**KIRKLEES METROPOLITAN COUNCIL  
INVESTMENT & REGENERATION SERVICE**

Reference No:	<b>2025/62/92718/W</b>
Site Address:	16, High Green, Lepton, Huddersfield, HD8 0HW
Description:	Erection of rear extension and associated alterations
Recommending Officer:	Kirsty Nicholls

## **Officer Report – 2025/92718**

Drawn	CD & CA
Date	April 2025
Scales	1:100 & 1:50 @ A0
Drawing No.	2529 - 0301 - R05

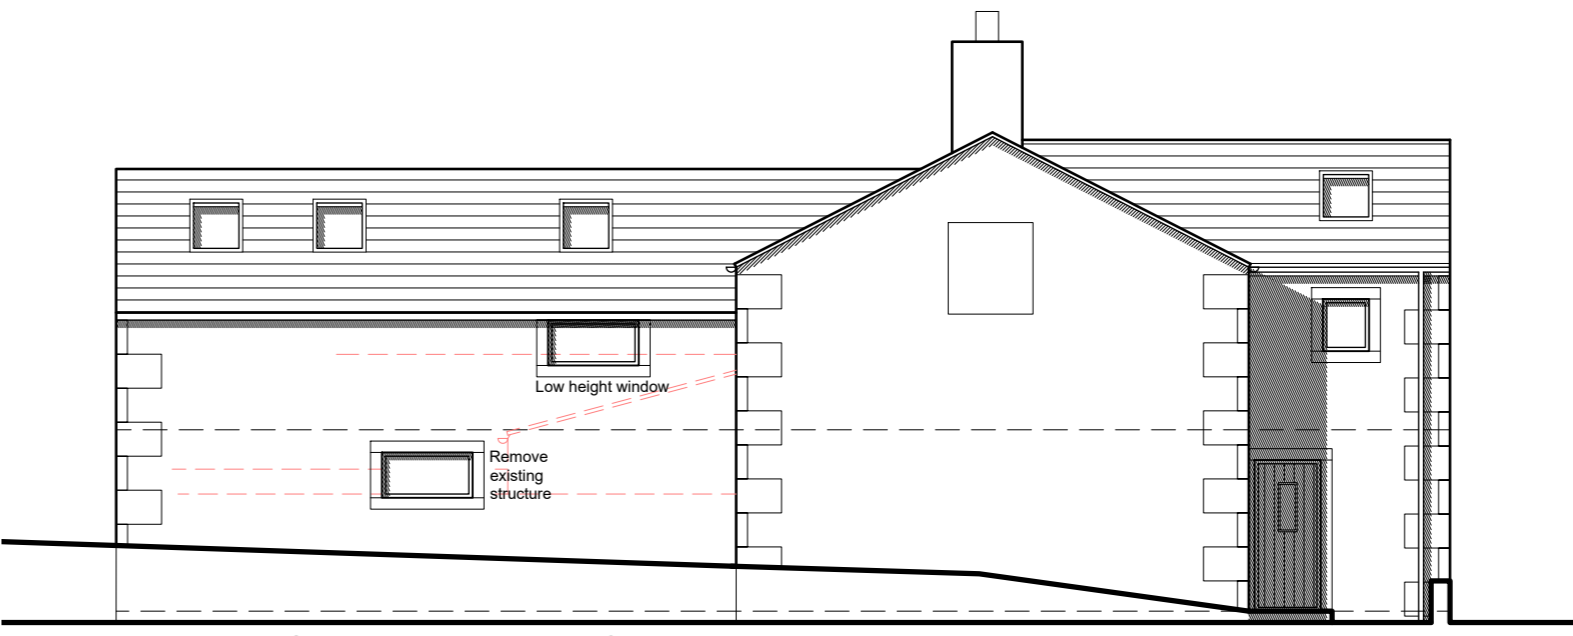
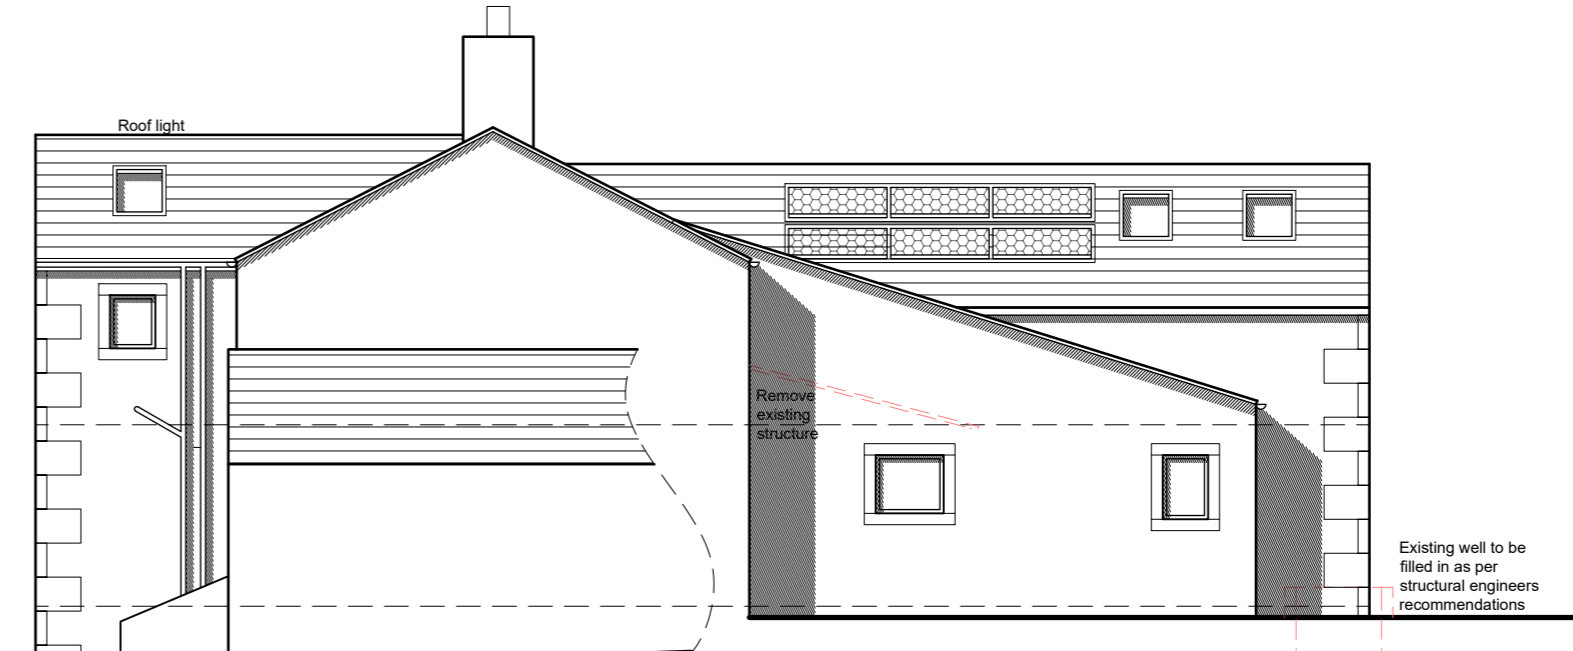
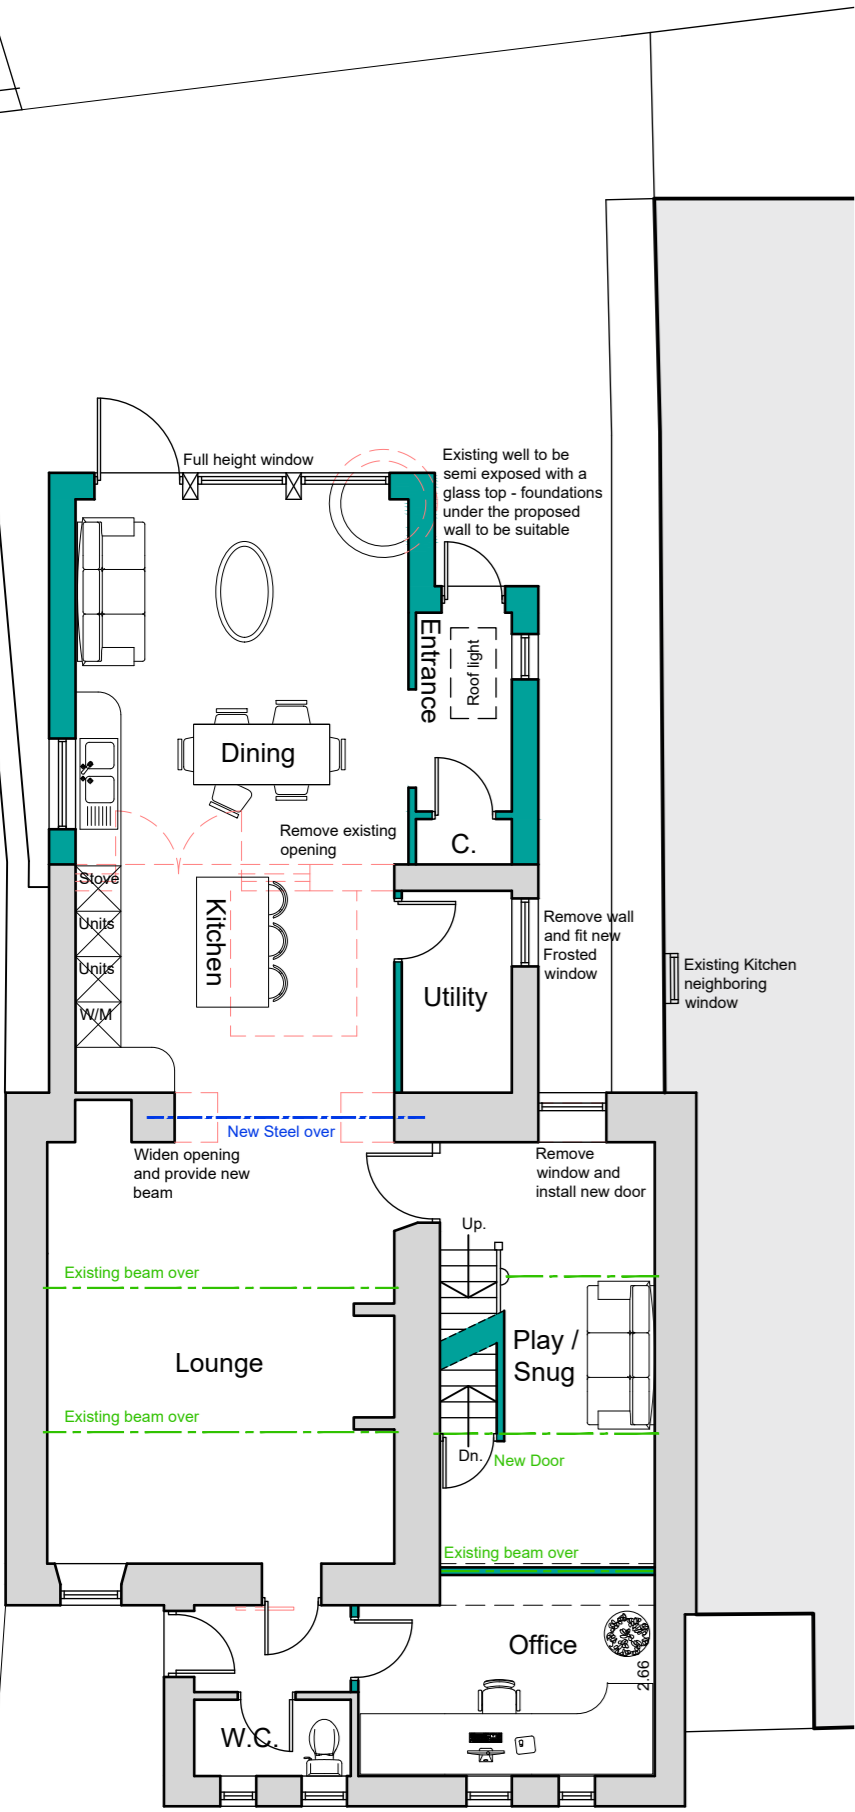
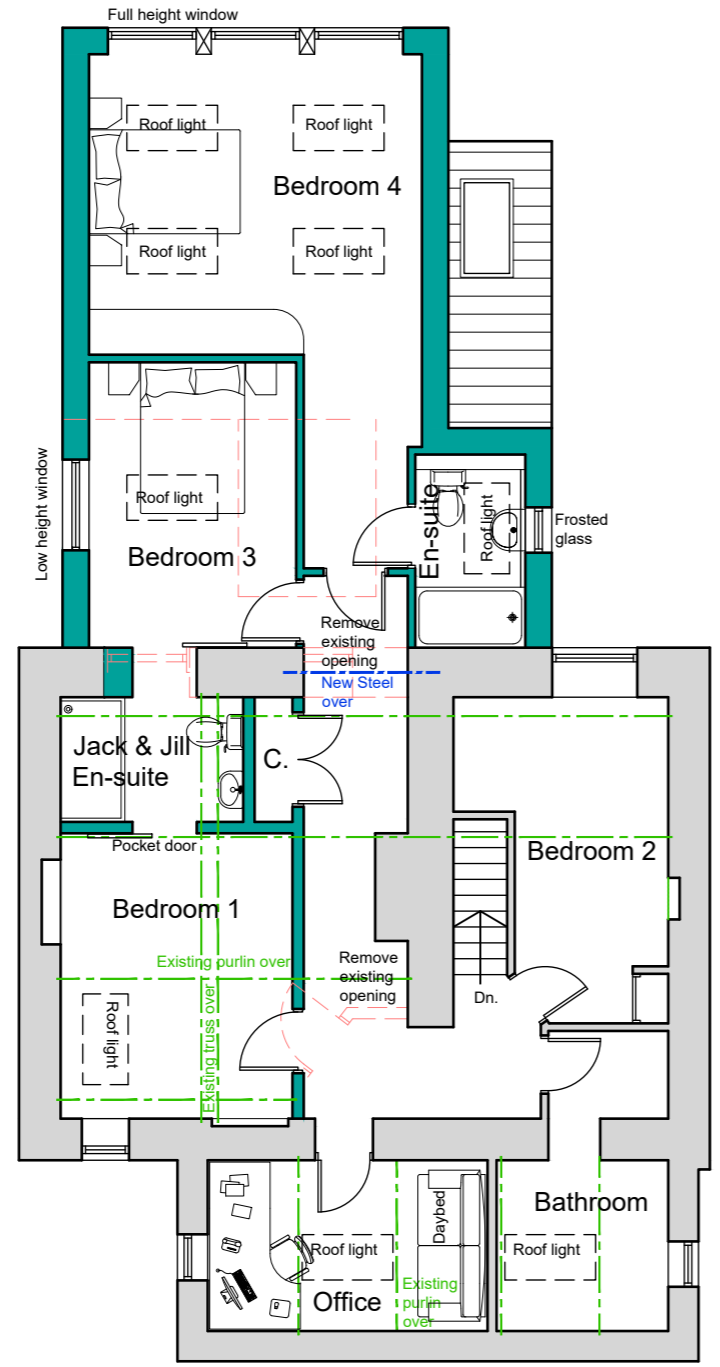
The bulk and mass (by virtue of its scale and projection) of the proposed extension as originally submitted was considered to result in an extension that would not be subservient in relation to the host dwelling. Officers requested that it be reduced substantially. Further to this, as a result of the scale of the proposal, there were concerns in relation to the potential overbearing impact

of the extension upon the amenity of occupiers of 14 and 15 High Green to the east.

The originally submitted plans incorporated an extension of which was considered to lack subservience by virtue of its scale and projection.

As a result of the scale of the proposal, the originally submitted proposals raised concerns in relation to the potential overbearing impact of the extension upon the amenity of occupiers of 14 and 15 High Green to the east of the property. Amended plans were received which lowered the height of the extension and also reduced its length. The outline of these properties was also indicated on the amended plan to better indicate the relationship between these properties and the application property as extended. These interventions act to mitigate any significant harm to these neighbouring properties in terms of overbearing impact.

Amended plans were received which lowered the height of the extension and also reduced its length. Both these interventions provide adequate subservience to the extension, reducing the impact on the existing property and were considered to address officers' concerns.

Drawn: DRH
Date: April 2025
Scales: 1:100 @ A1
Drawing No.: 2529 - 0101 - P03

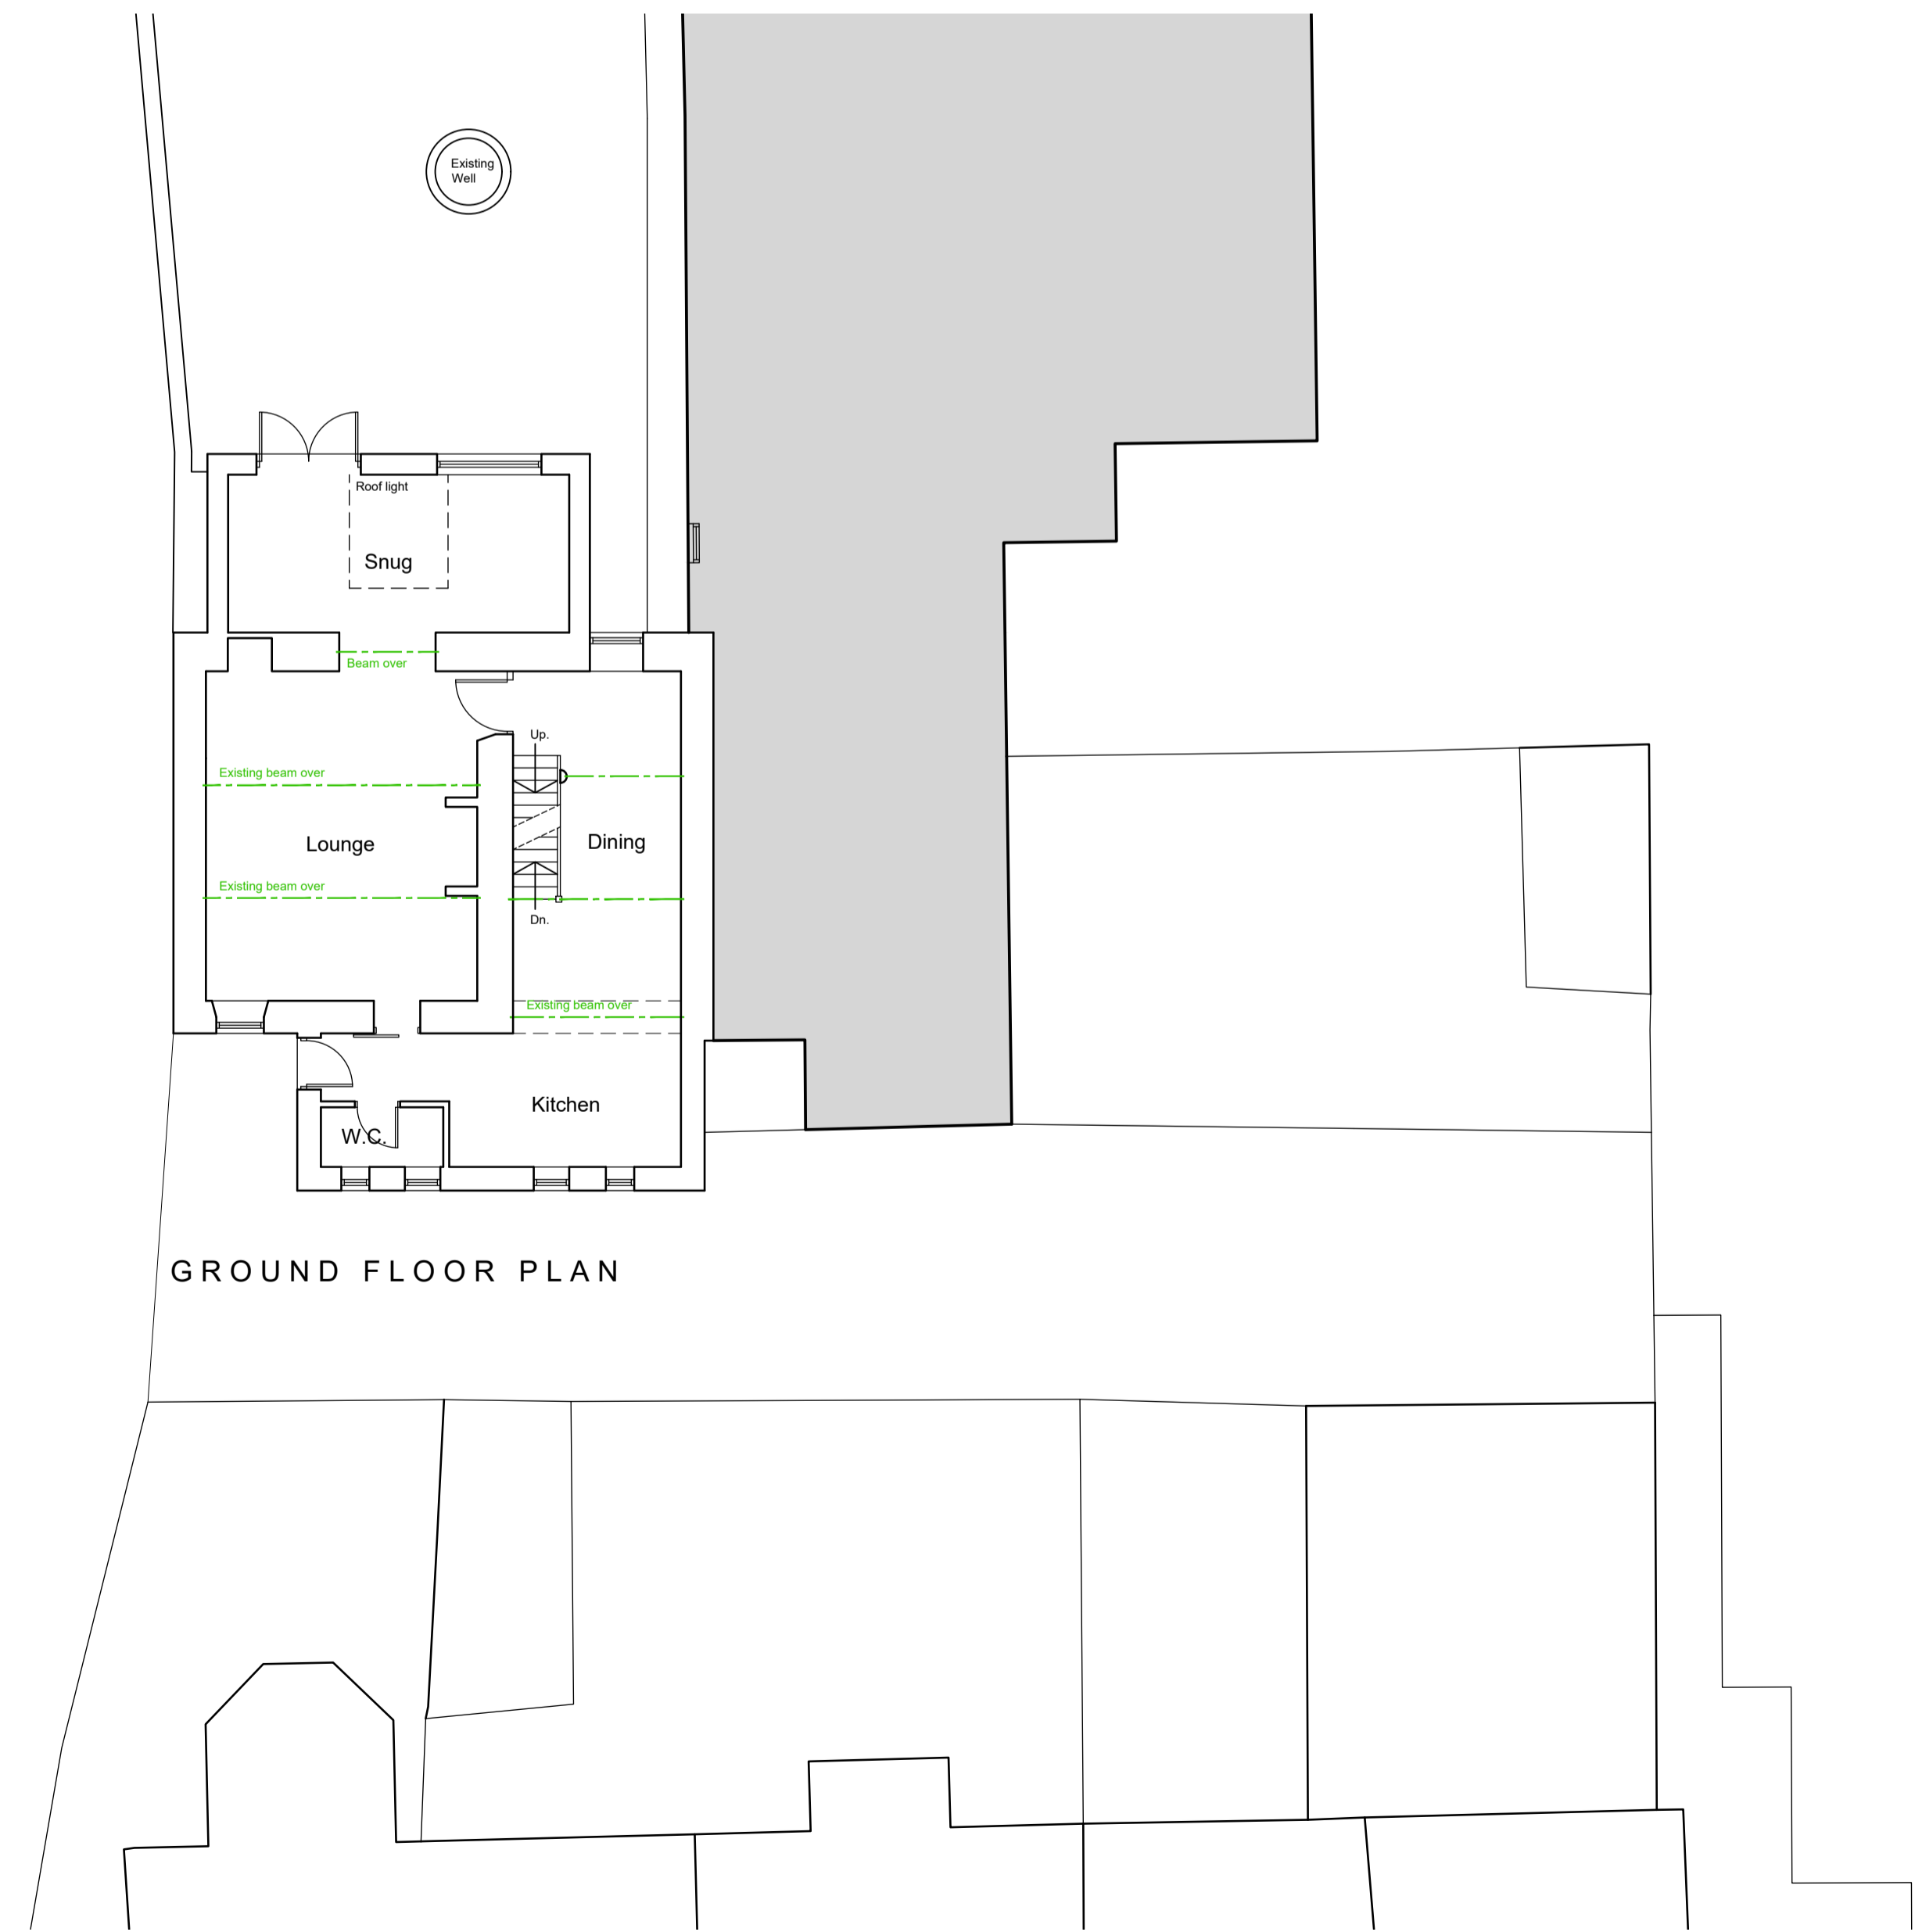
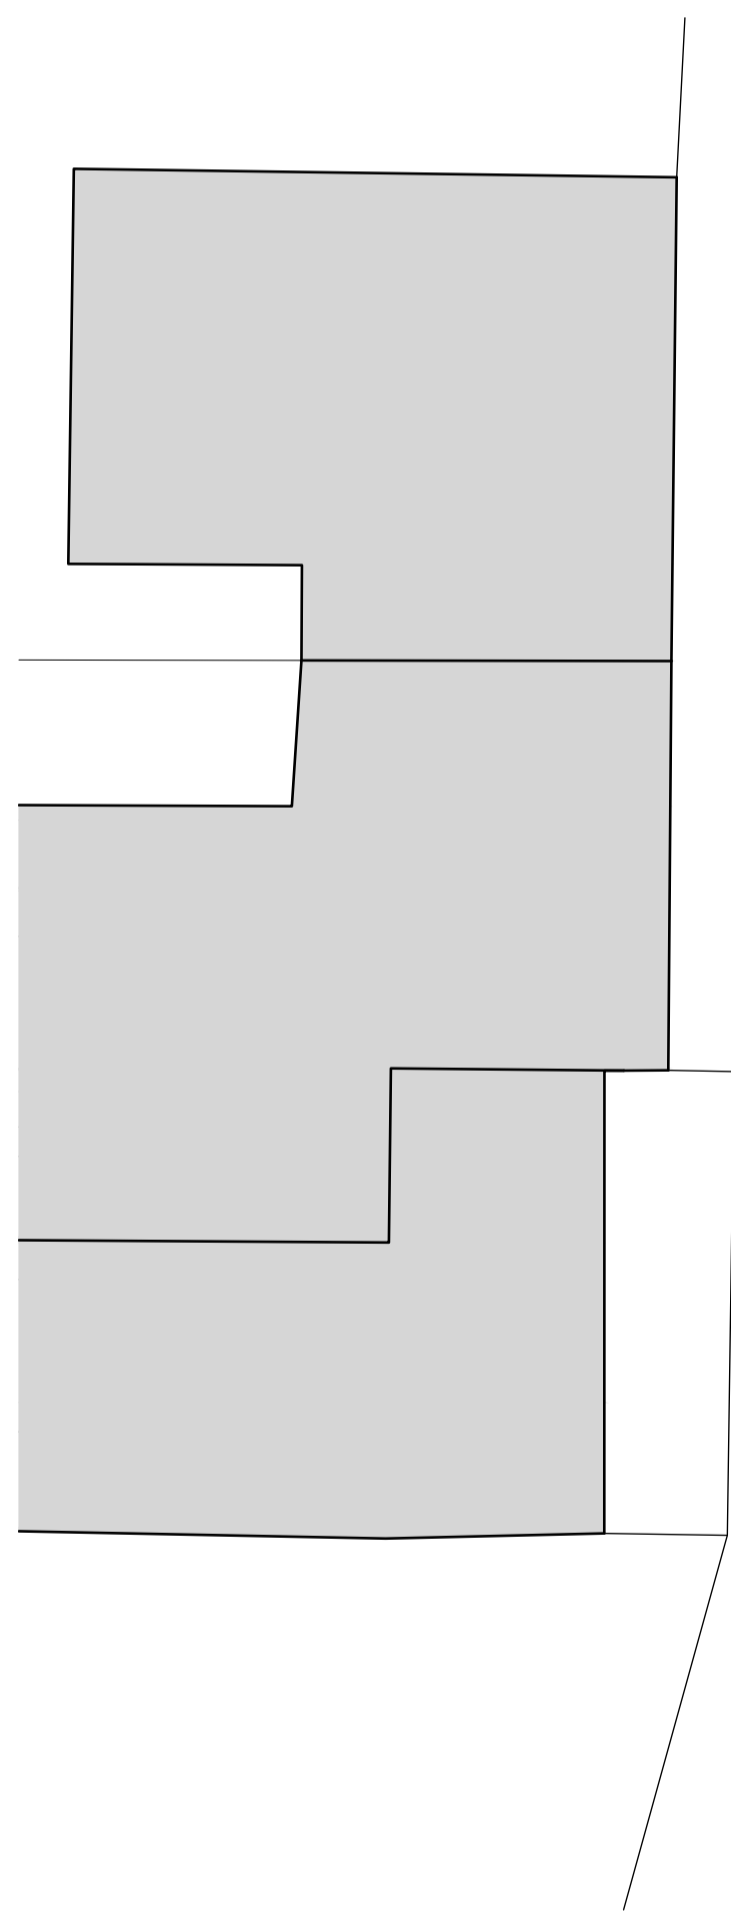
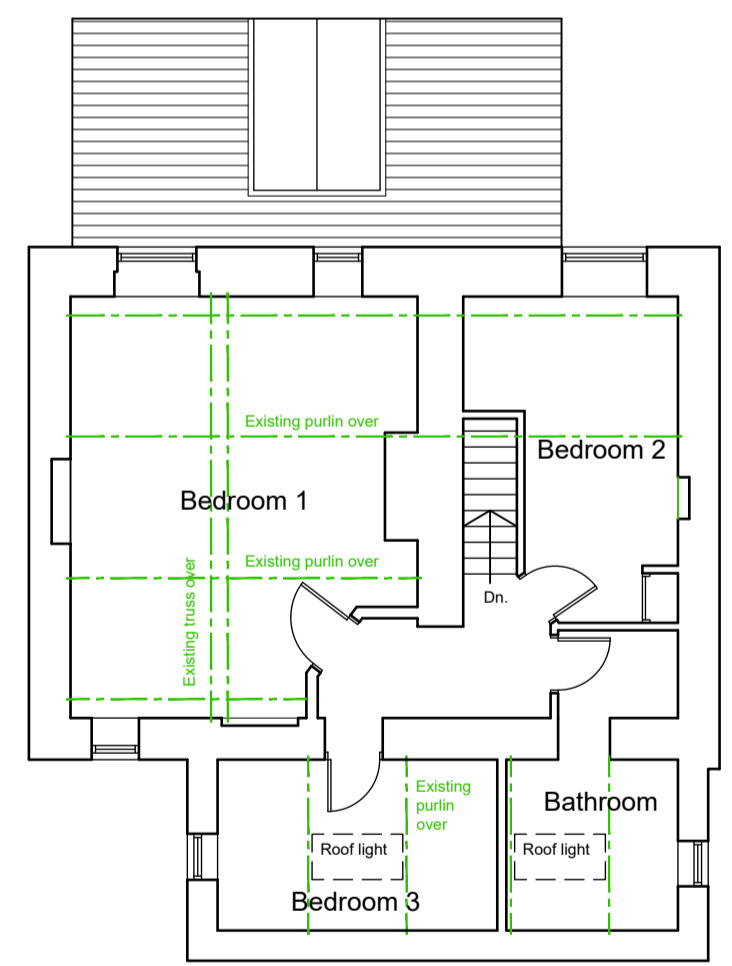
In addition, the red line boundary of the application site as originally submitted included land outside of the domestic curtilage and it was requested that this be reduced to include only that land within the curtilage of the application site. Amended plans were submitted of which officers considered addressed the above concerns. Further details are contained within the Assessment section of this report.

In addition, the red line boundary of the application site as originally submitted included land outside of the domestic curtilage and it was requested that this be reduced to include only that land within the curtilage of the application site. Amended plans were submitted which officers considered addressed the above concerns.
